**GLEBE ISLAND EXPO (SSD 5589 – 2012)
ADDENDUM TO SUBMISSIONS REPORT**

Further to our Submissions Report dated 18 February 2013 and subsequent meeting on 19 February 2013, we wish to make the following amendments to the proposed development.

SITE SURVEY INFORMATION HAS NOT BEEN PROVIDED TO ACCURATELY INDICATE EXTENT OF BOUNDARIES DETERMINING THE TOTAL NUMBER OF CAR SPACES. TRAFFIC CONSULTANT AND SITE SURVEY INFORMATION NOT CO-ORDINATED.

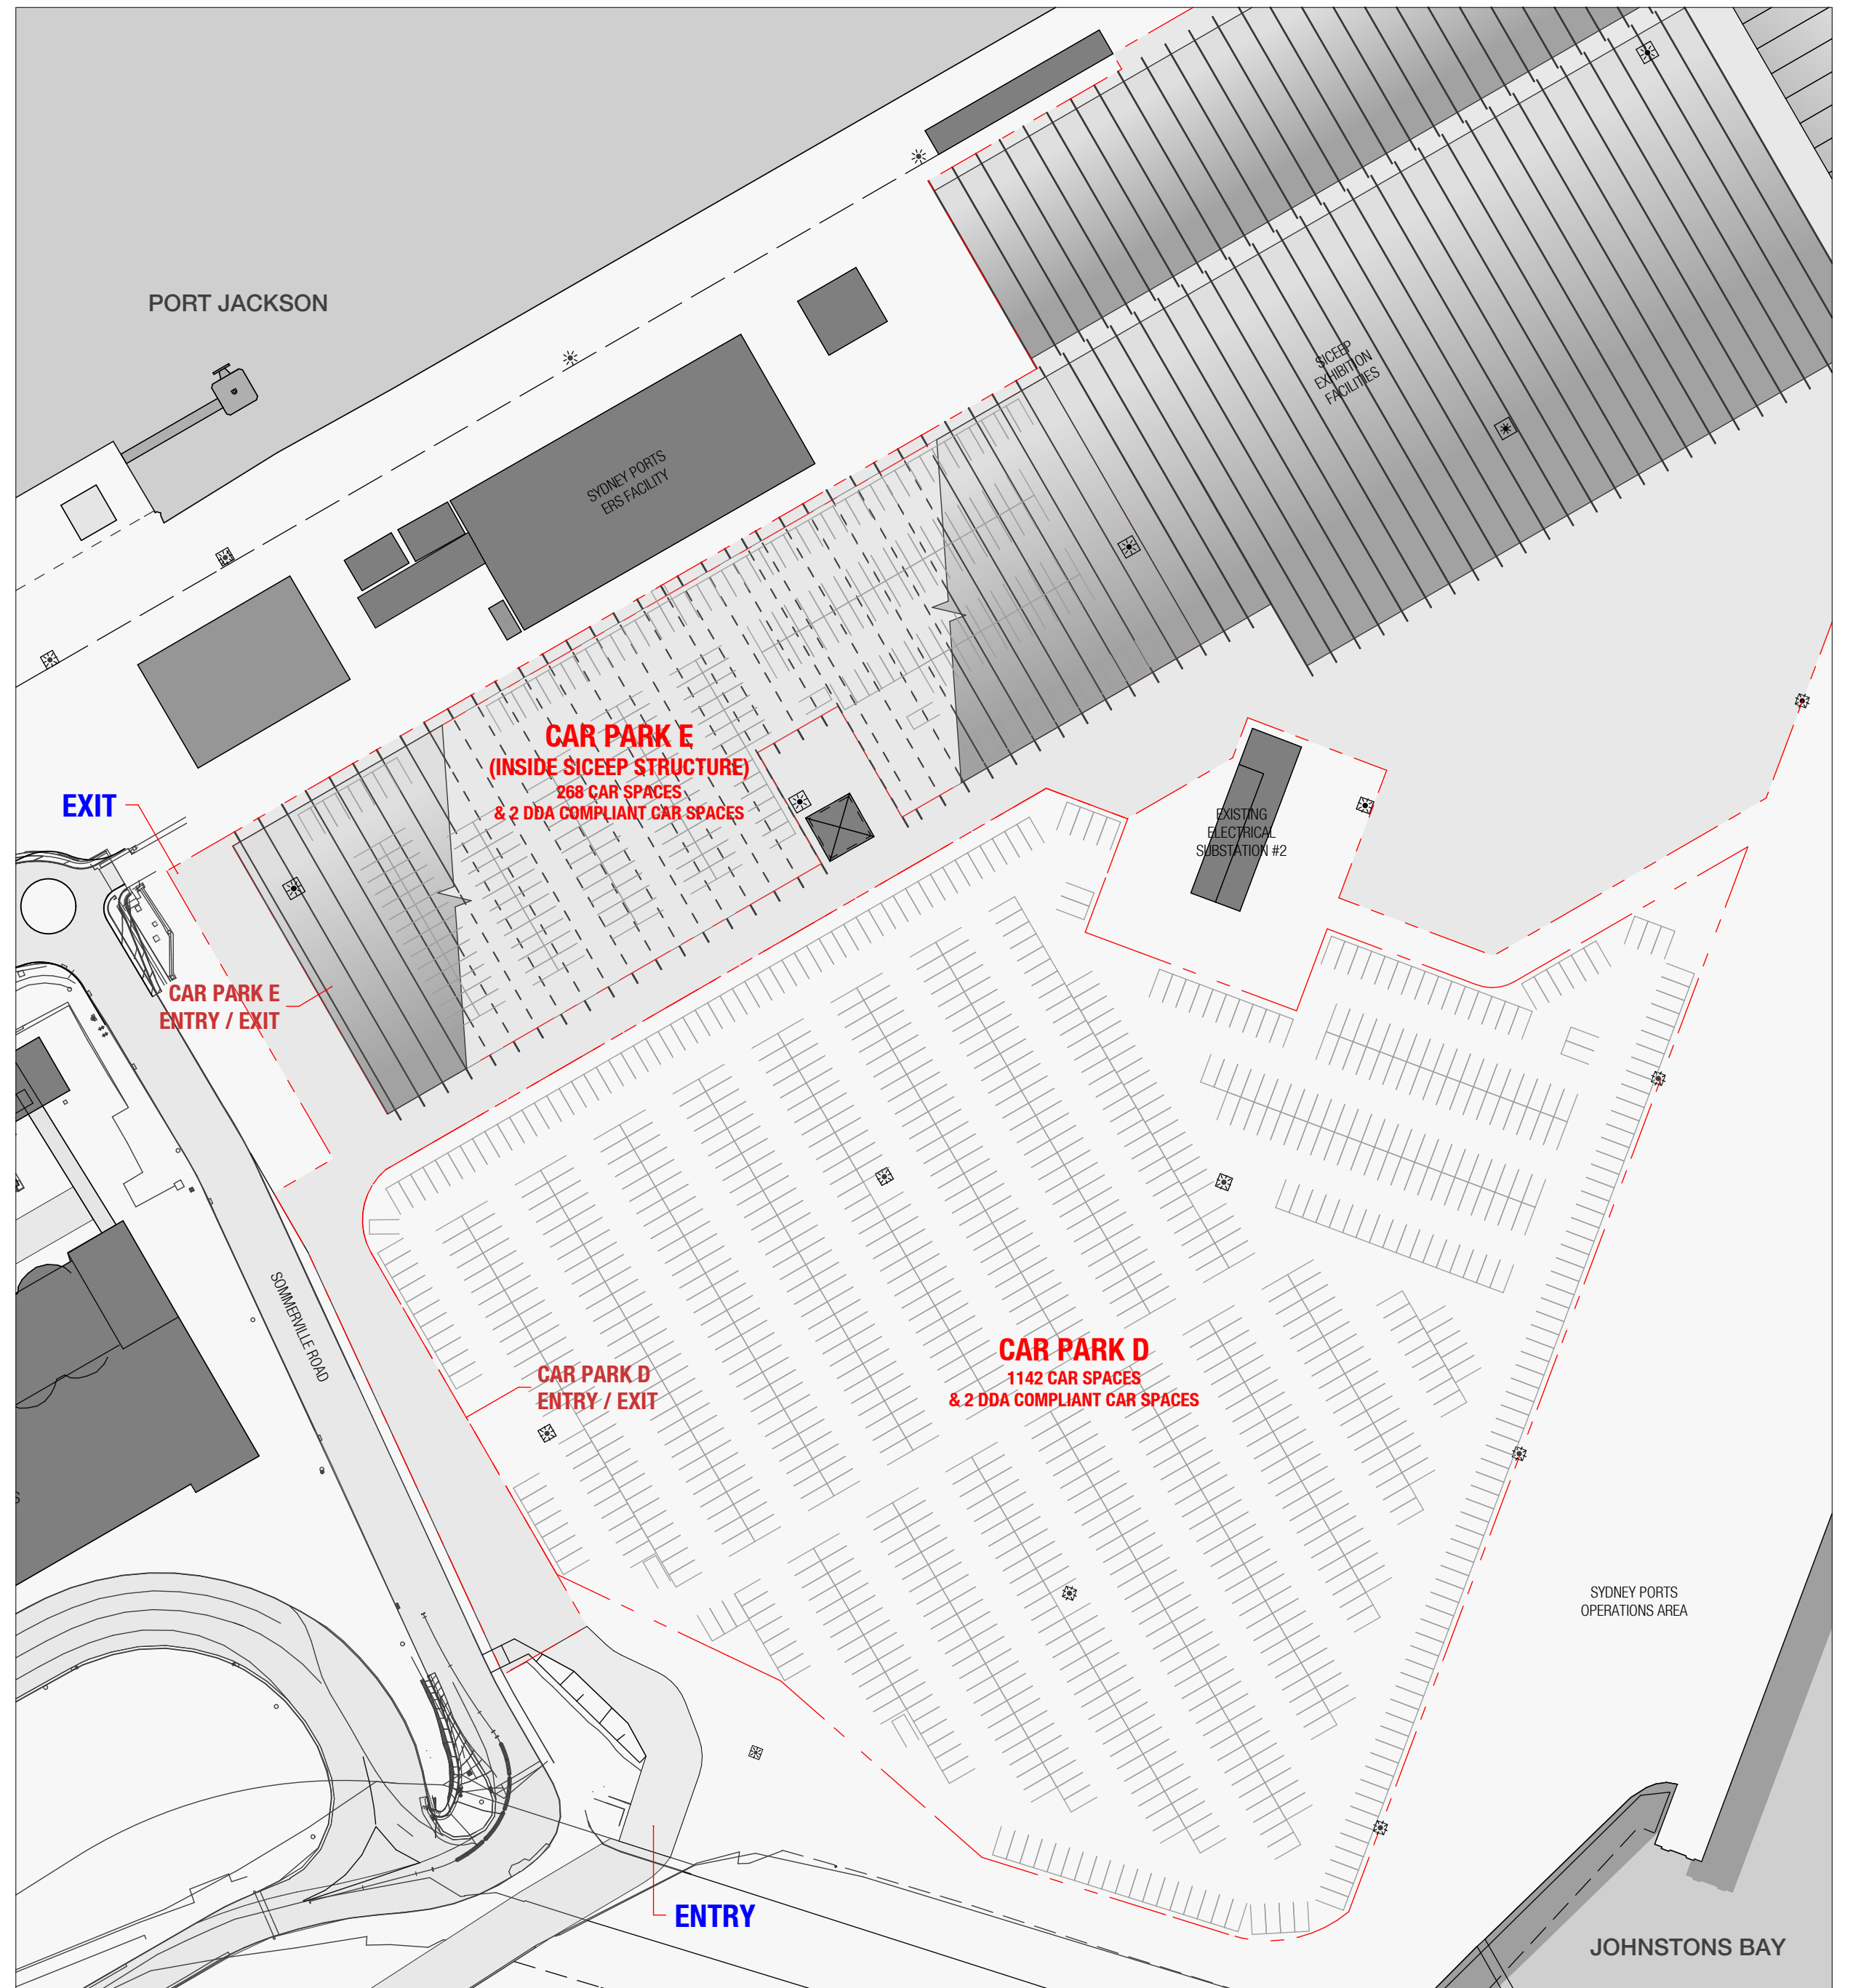
Development consent is sought for 1,000 vehicles. A total of 1,000 car parks will be provided within Sydney Ports' precinct by utilising the following locations:

- Hardstand area at the front of the White Bay Power Station (Car Park A, up to 385 spaces);
- Land to the north of White Bay Wharf No. 4 (known as the long term car park for the White Bay Cruise Passenger Terminal) (Car Park C up to 100 spaces); and
- Within Exhibition Hall 01 when not utilised for an exhibition event (Car Park E, up to 268 car spaces).

Additional overflow car parks in the following areas, the exact location depending on port requirements at the time:

- Additional Areas on Glebe Island (Car Park D, up to 1,038 car spaces) and / or
- Areas at White Bay (Car Park B, up to 446 spaces).

The proposed areas of car parking are shown on Architectural Drawing Nos. A2700-A2702 (Revision C) prepared by Woods Bagot and included at Appendix A.

The total number of car spaces to be used in any event will be no more than 1,000 car spaces. The location of those 1,000 car spaces will be determined on an event by event basis and documented in the Travel Management Plan to be prepared for each event.
